**APPELLANT'S COMMENTS ("AC") TO PREVIOUS APPEAL DECISION –
ANNOTATED IN RED WITHIN (with Appendices AC1, AC2 and AC3 attached)**

Appeal Decision

Appeal Ref: APP/R5510/W/21/3268811

38 Hazeldene Gardens, Uxbridge, UB10 9DJ

Job title 38 HAZELDENE GARDENS UXBRIDGE UB10 9DJ			
Drawing title PROPOSED ELEVATIONS			
Job No 1913_PL05	Scale @ A3 1:100	Date	Drawn by RJ

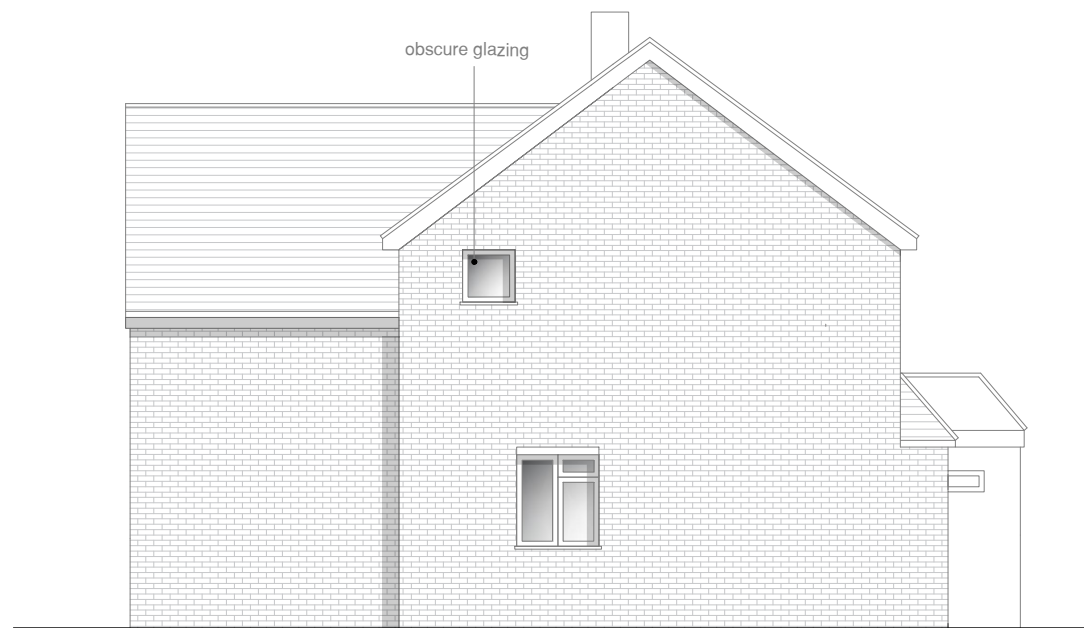
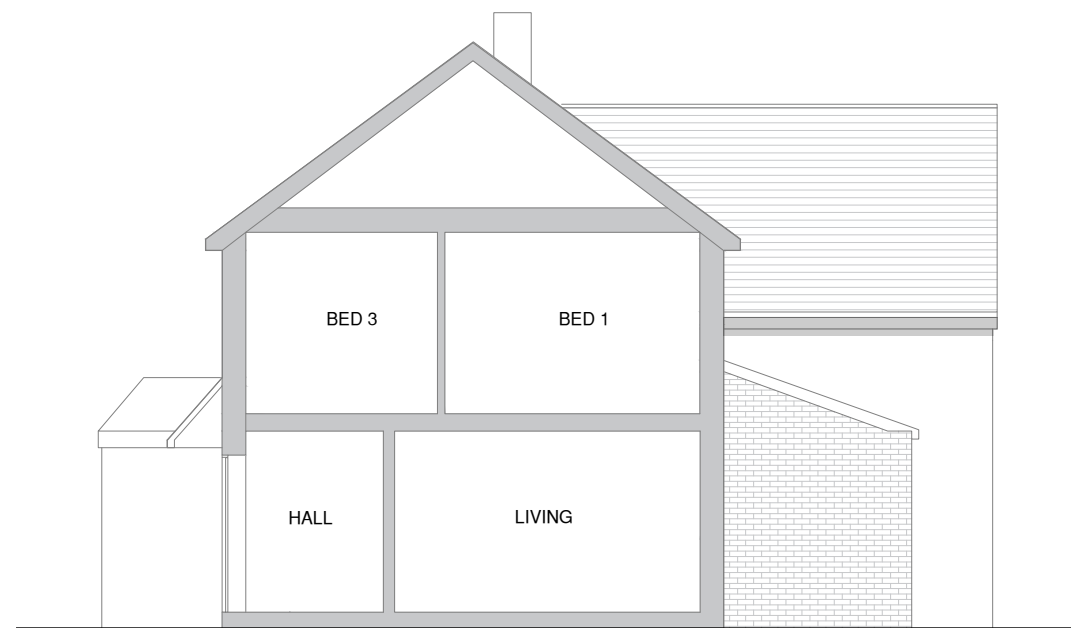
10. The projection of the proposed dwelling close to the rear elevation and a first floor window of No 38 combined with its height and depth would have a detrimental effect on the outlook from this windows. The proximity of the proposed dwelling to this window would significantly restrict levels of light entering it, which would result in the room it serves being unduly gloomy to the detriment of their usability and the occupants of No 38.

AC: The inspector did not request entry into or carry out internal site observations from the rear rooms of No 38 and externally the site was covered with scaffolding which is temporary. The Appellant says there are several mitigating factors that ought to be taken into account: 1) the projection at first floor is comparatively (see Appendix AC1 and AC2 examples) of modest depth and height with the pitch of the roof bearing away from No 38; 2) the rear window of the closest habitable room is reasonably wide and not tight to the boundary but is set away some distance from it providing self-mitigation (cf. at 14 Westerdale the single sash narrow window was tight to the boundary but the compensatory effect was provided by the first floor off-shoot of the new dwelling slightly set away from the boundary); 3) the open expanse at the rear and the absence of any other nearby projections would provide more than adequate sunlight and daylight into the room and an acceptable outlook from that room, in the Appellant's submission; respectfully the Appellant says the inspector's characterisation above is unduly harsh; 4) it was not previously specifically canvassed to the previous inspector, but it has been canvassed now (at paragraph 1.5 of Appellant's Reply of 21 December 2021), that the LPA itself had previously come to the same judgment when it had approved 57039/APP/2018/6640 – at page 5 of the delegated report (see within Appendix 4 of the Appellant's Appeal Statement) it had adjudged that (emphasis added): "It is considered that all the proposal habitable rooms **and those altered by the development would still maintain an adequate outlook and source of natural light.**" Its *volte face* now just because a new dwelling is instead being proposed for the same projection is a paradigm example of inconsistency, unfairness and unreasonable behaviour, the Appellant says; 5) with a degree of foresight and to provide further mitigation for the planning balance, in the instant proposal the Appellant has provided for an internal layout change at first floor of No 38 such that the nearest habitable room at the rear would now be even further away from the new dwelling's projection. This was not even taken into account by the LPA in its statement in reply, although it would inevitably have been by the case officer to warrant her recommendation for approval.

Project no. / Stage / Drawing no. / Revision
0165 PLA- 51_B

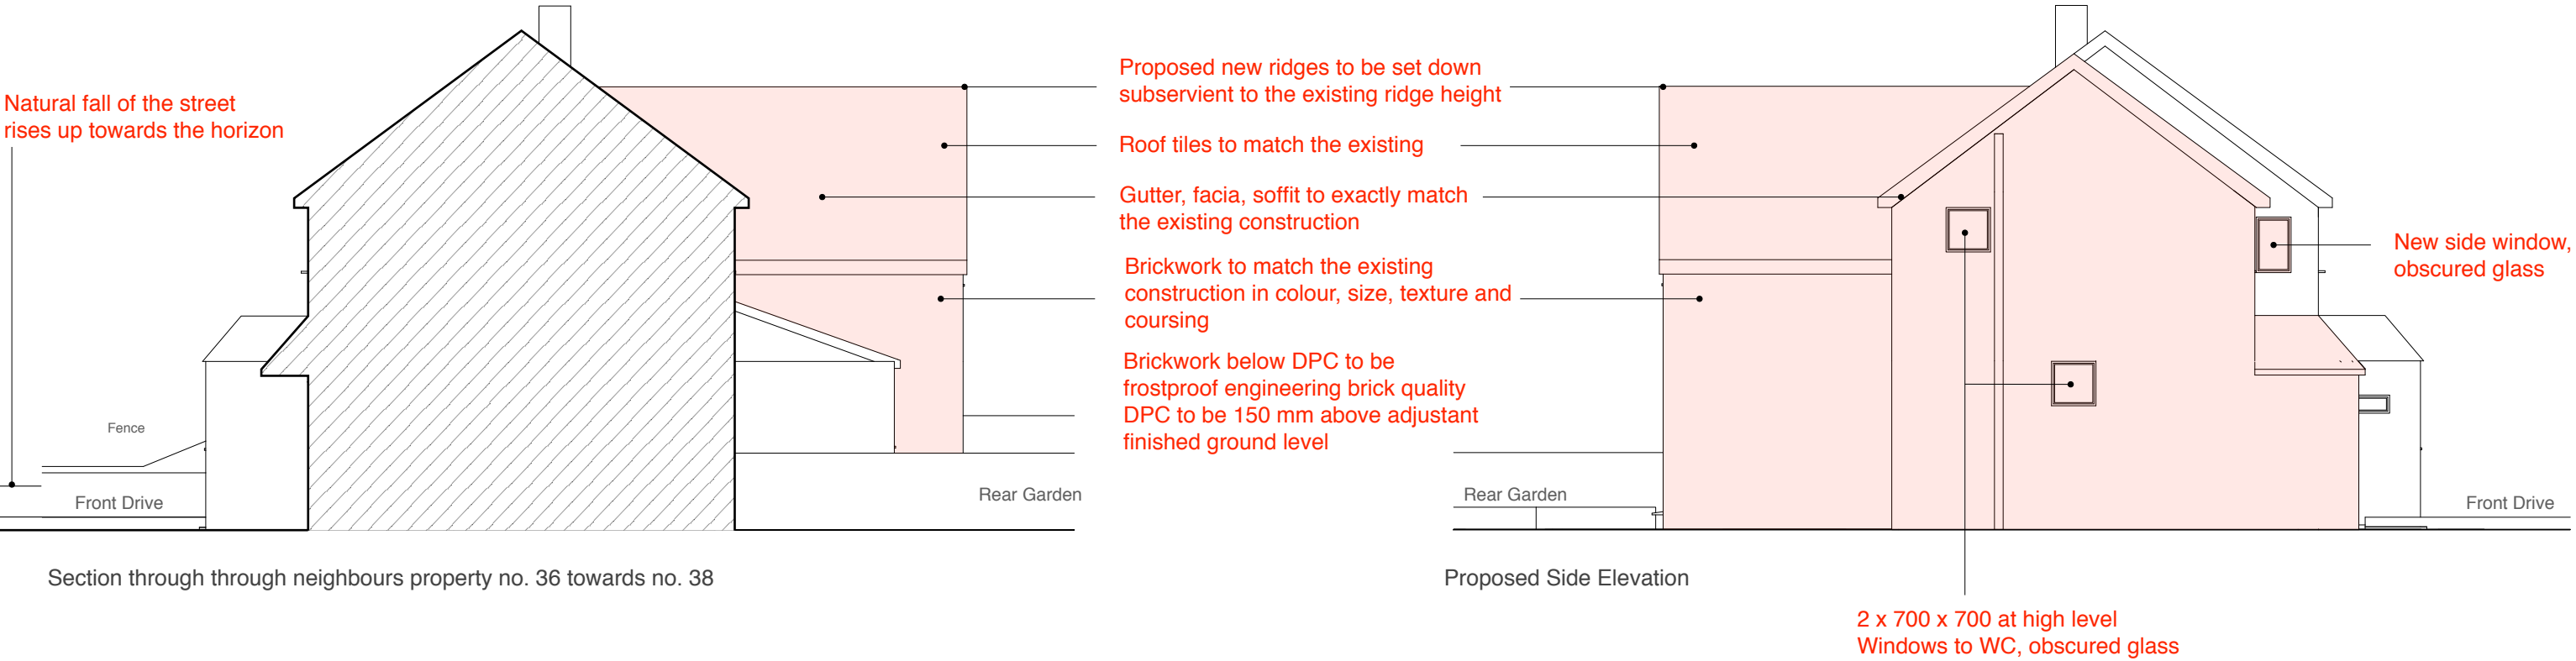
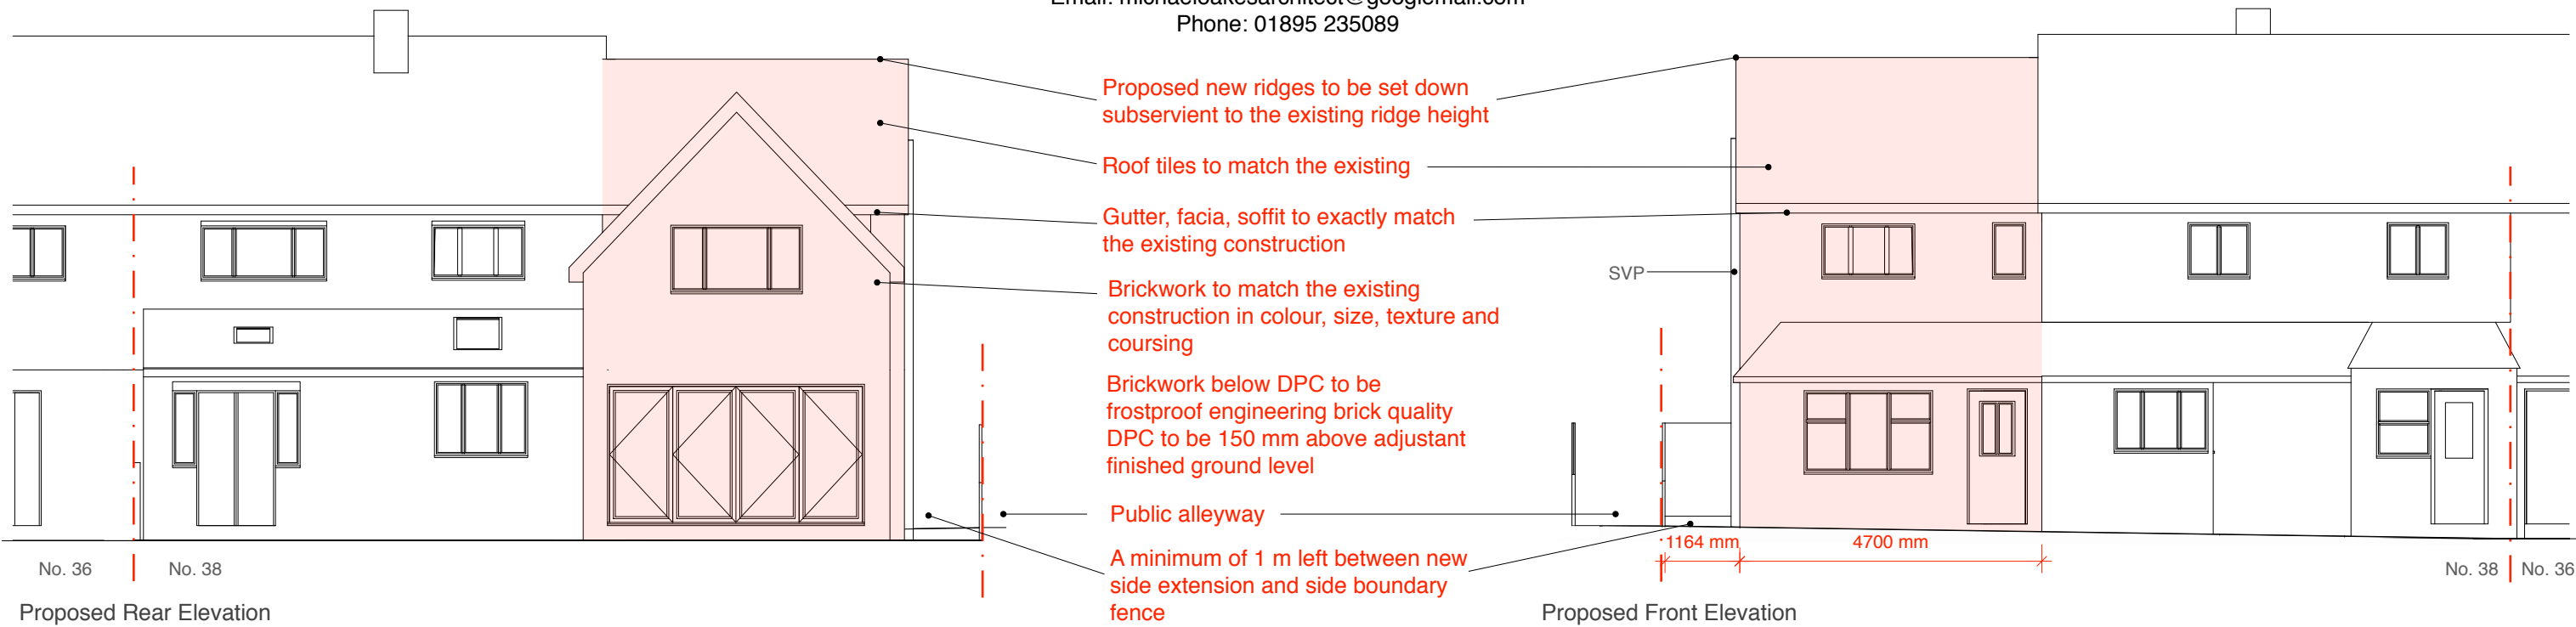
AC: The amended proposal is directly comparable to the approved and implemented development under 57039/APP/2018/664. In fact, as previously averred, 57039/APP/2018/664 incorporates an approved much wider two storey form plus an additional front door at street level elements which would not be deemed policy compliant either for a two-storey side extension or an annexe under the present policy context. Yet approval as a separate dwelling would work in the other direction

AC: As the Appellant says the LPA itself has held under the approved scheme that there would be no unacceptable impact on light or outlook on the habitable rooms of No 38; the current proposal replicates the approved scheme and hence it is only fair and consistent to reason rationally that the light and outlook will not be unacceptably impacted.
